CITY OF ALBUQUERQUE

**Re: 1315 Mountain Rd. NW
Request for Certificate of Occupancy - Permanent
Hydrology Final Inspection –Not Approved
Grading and Drainage Plan Stamp Date: 4/2/19
Certification dated: 9/1/20
Drainage File: J13D210**

DRAWING NAME:
GRADING & DRAINAGE PLAN

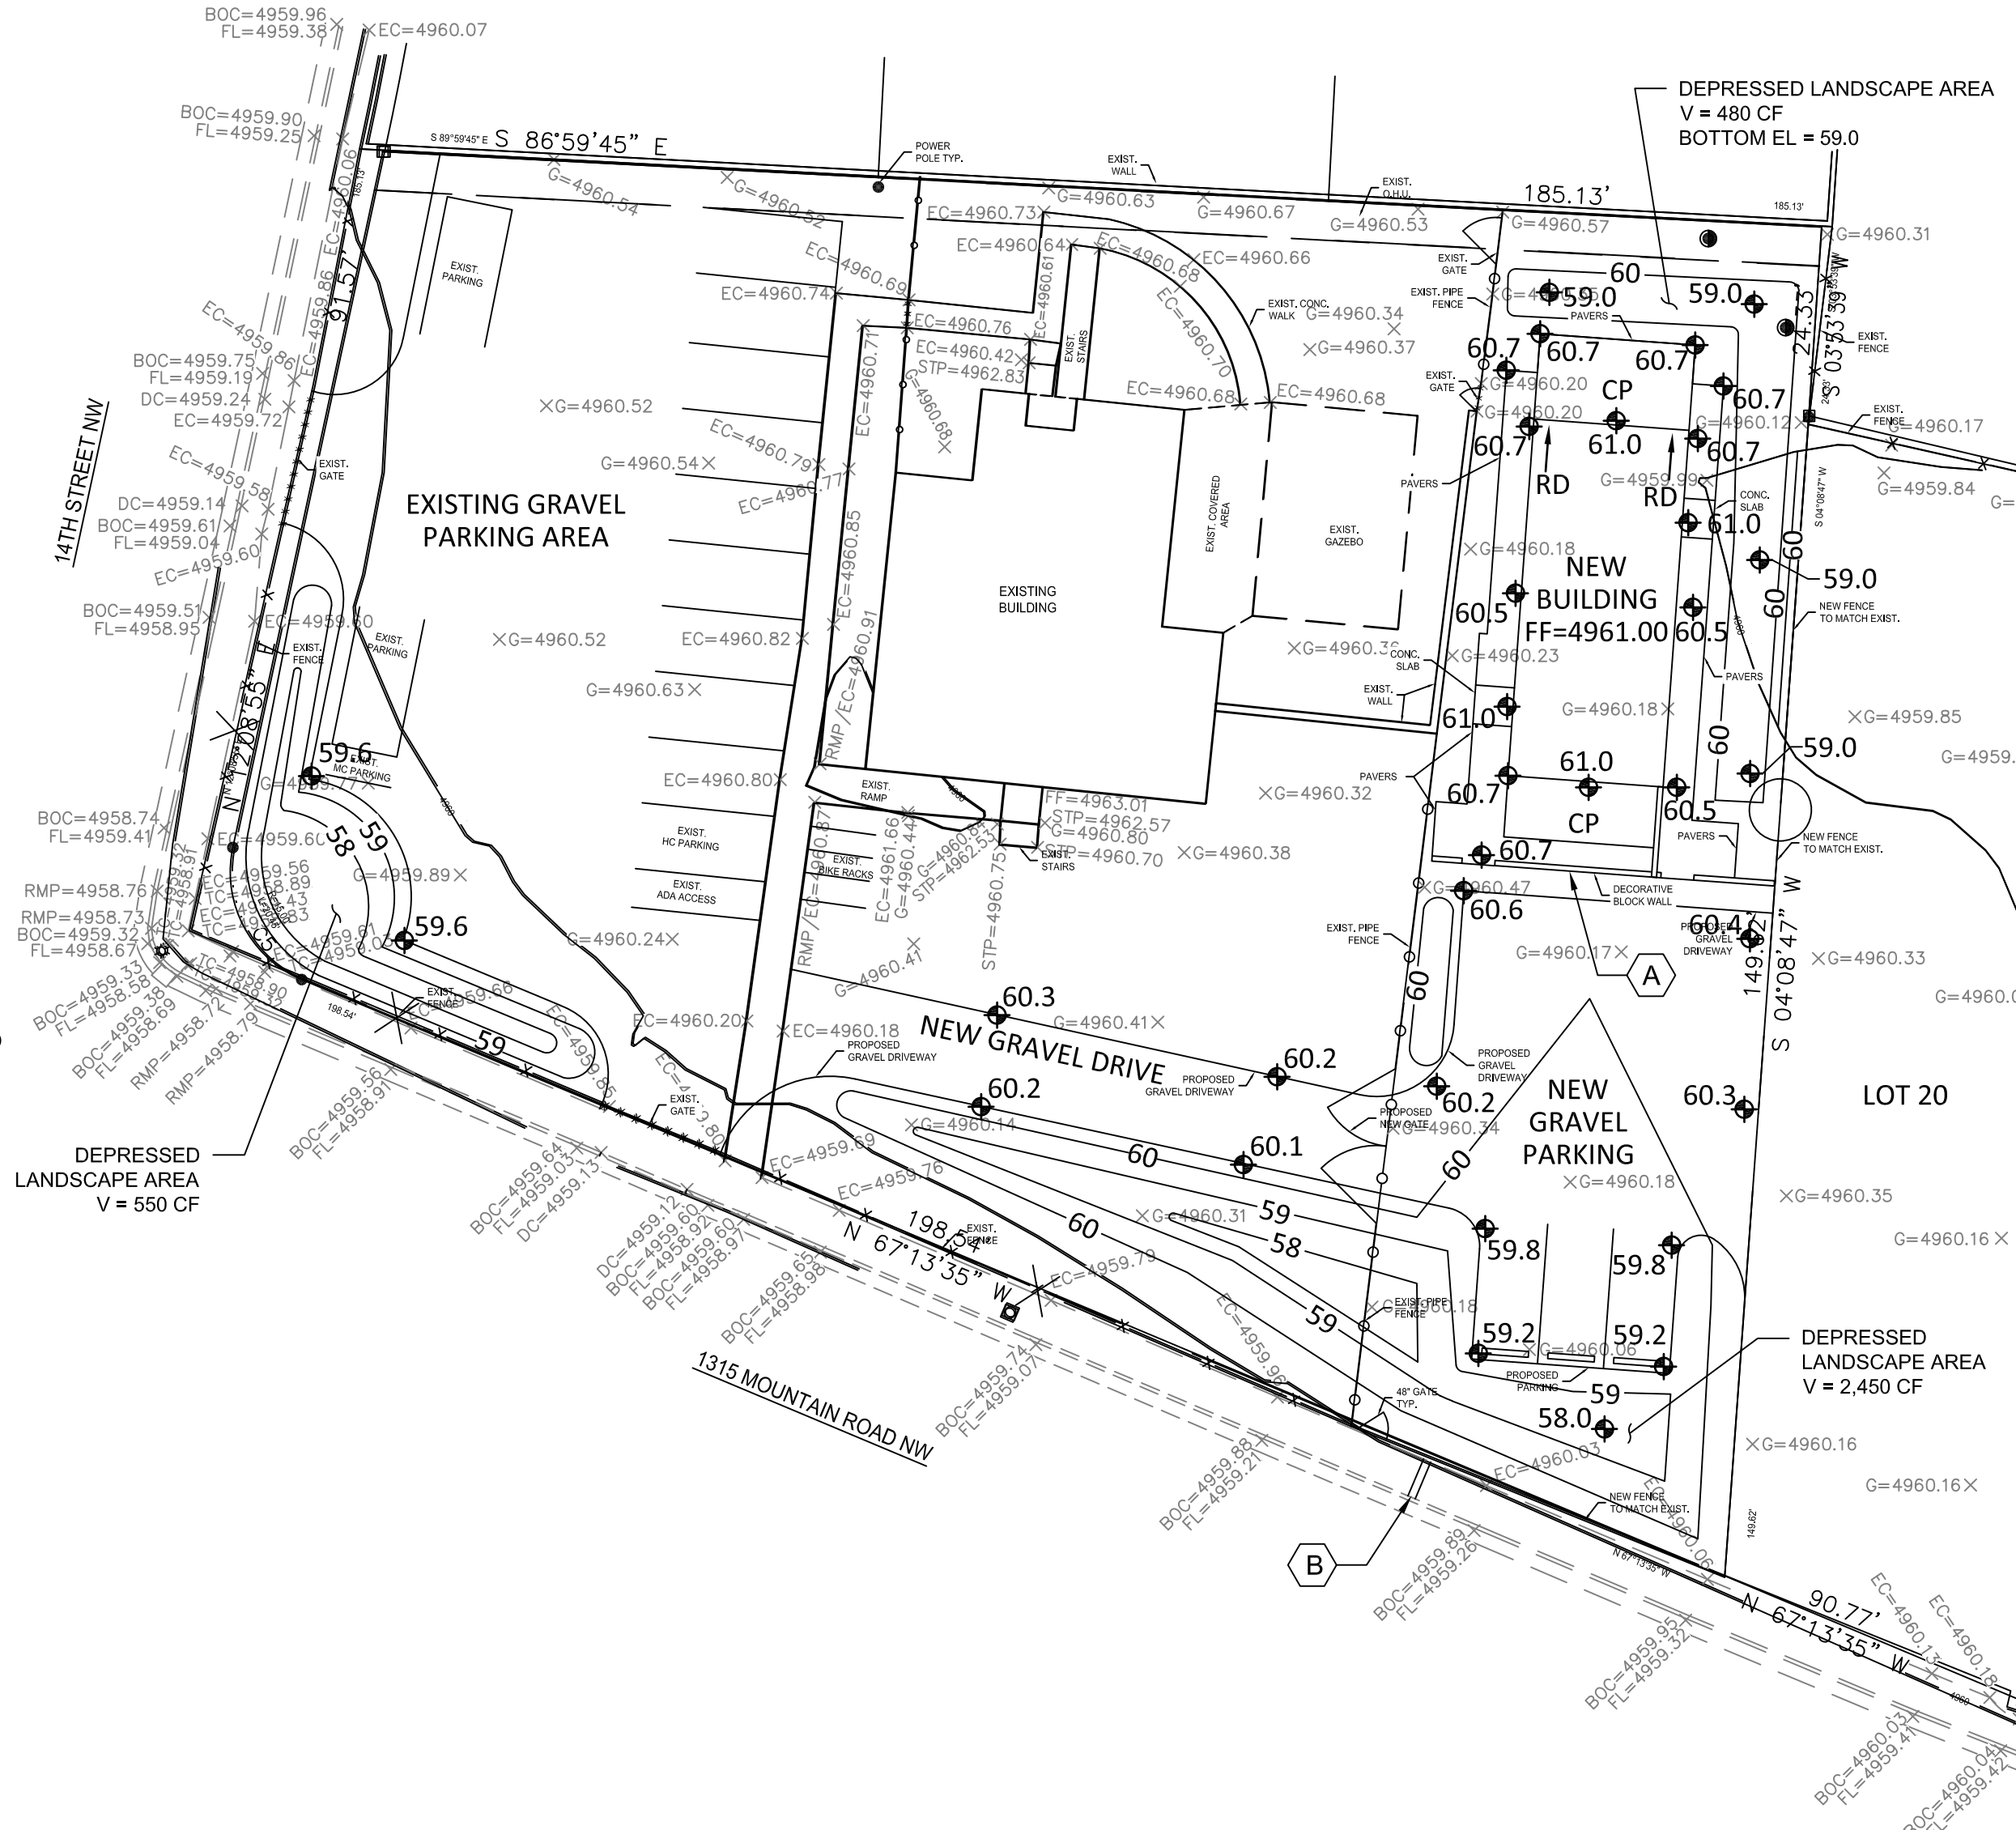
1. The first flush ponds shown on the plans were not constructed. These ponds need to be constructed or if you intend on using payment-in-lieu then you provide a receipt showing that this payment was made. Payment-in-lieu for this site would be calculated at \$8/CF which at 4,790 CF would be $8 \times 4,790 = \$38,320.00$
